Ray
8035 STARVED ROCK LANE
Payton CO 80831

Planning Comments [Review 1]

Site Plan _V1.pdf Markup Summary

IMPROVEMENT LOCATION CERTIFICATE

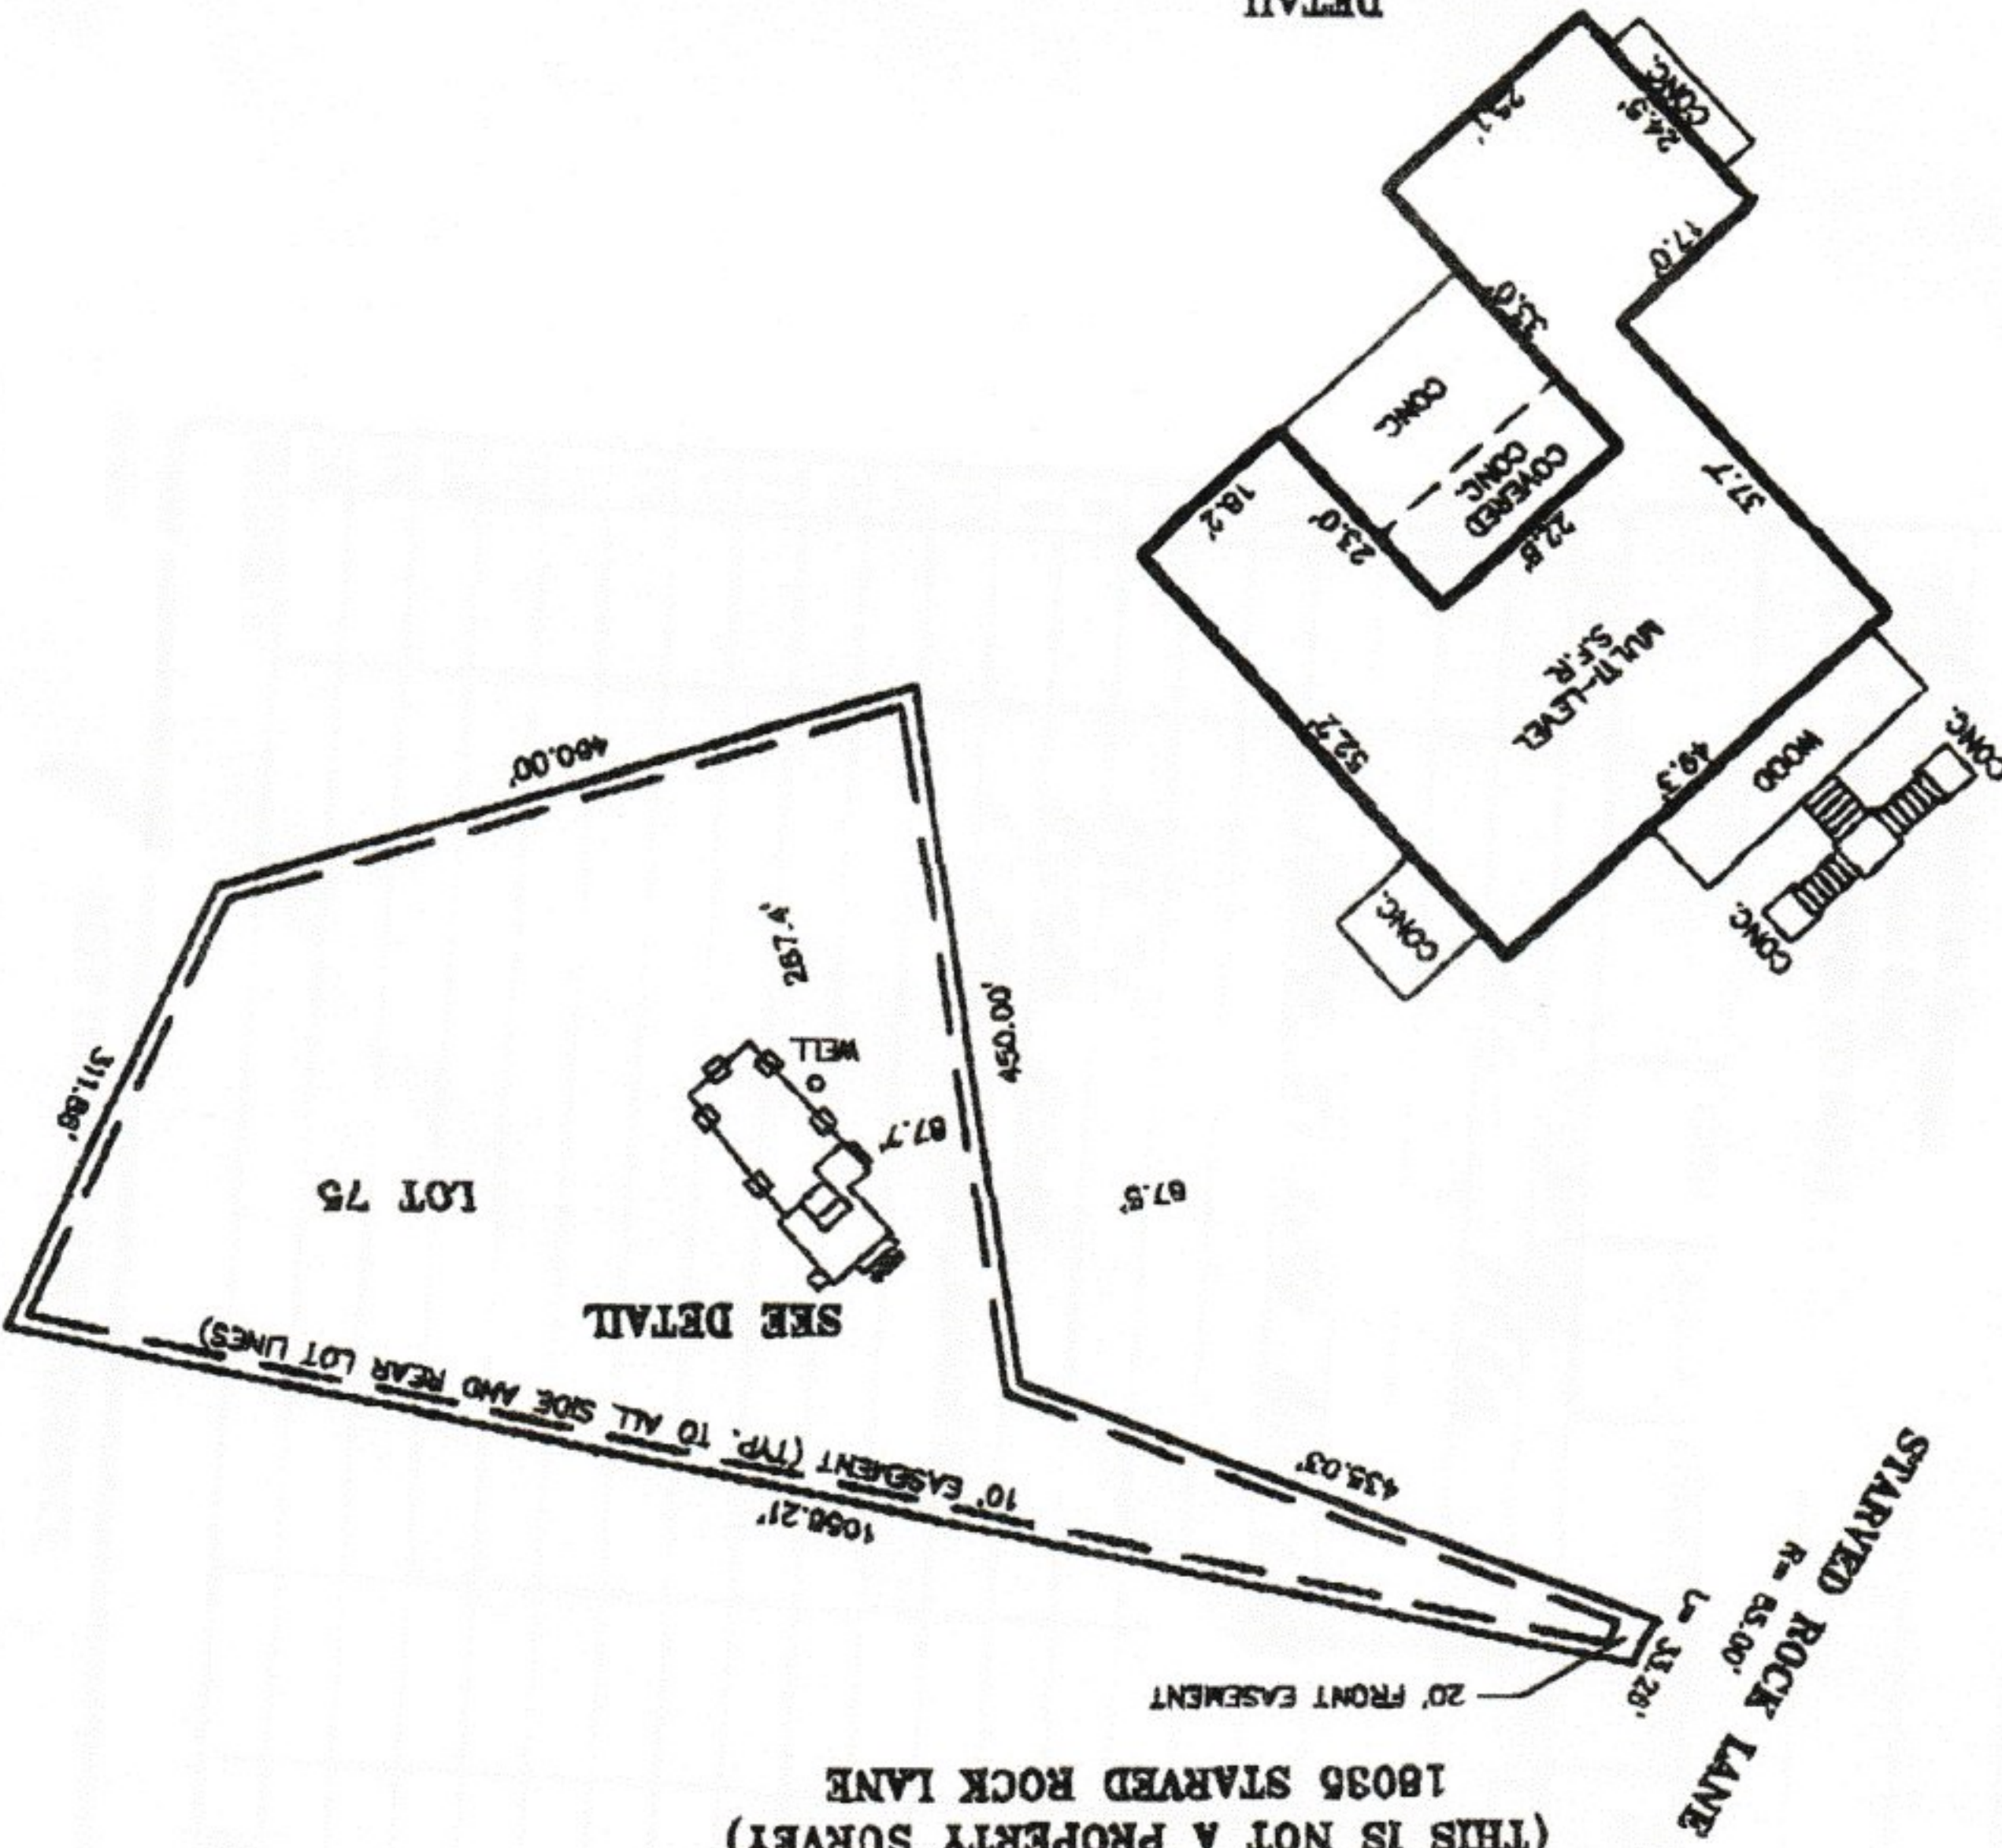
-Some of this plan is illegible (ink is too faint for house and its setbacks, etc.) as well as missing required information. Please add required site plan and property information to this plan. Please refer to the example site plan on our "site plan questions" web page via the below link. Please be sure to include everything that's noted on the example (scale, property parcel ID, lot coverage, clearly show **all** buildings (proposed and existing) and setbacks from **all** buildings to **all** property lines, street name where cul de sac meets property, zoning designation, etc.). There's also a Q&A for "what's required on a site plan".

-Please note that the proposed barn must also meet the 25-foot side setback requirement. The side setback from the proposed barn is not shown, so I'm unable to verify compliance in this review.
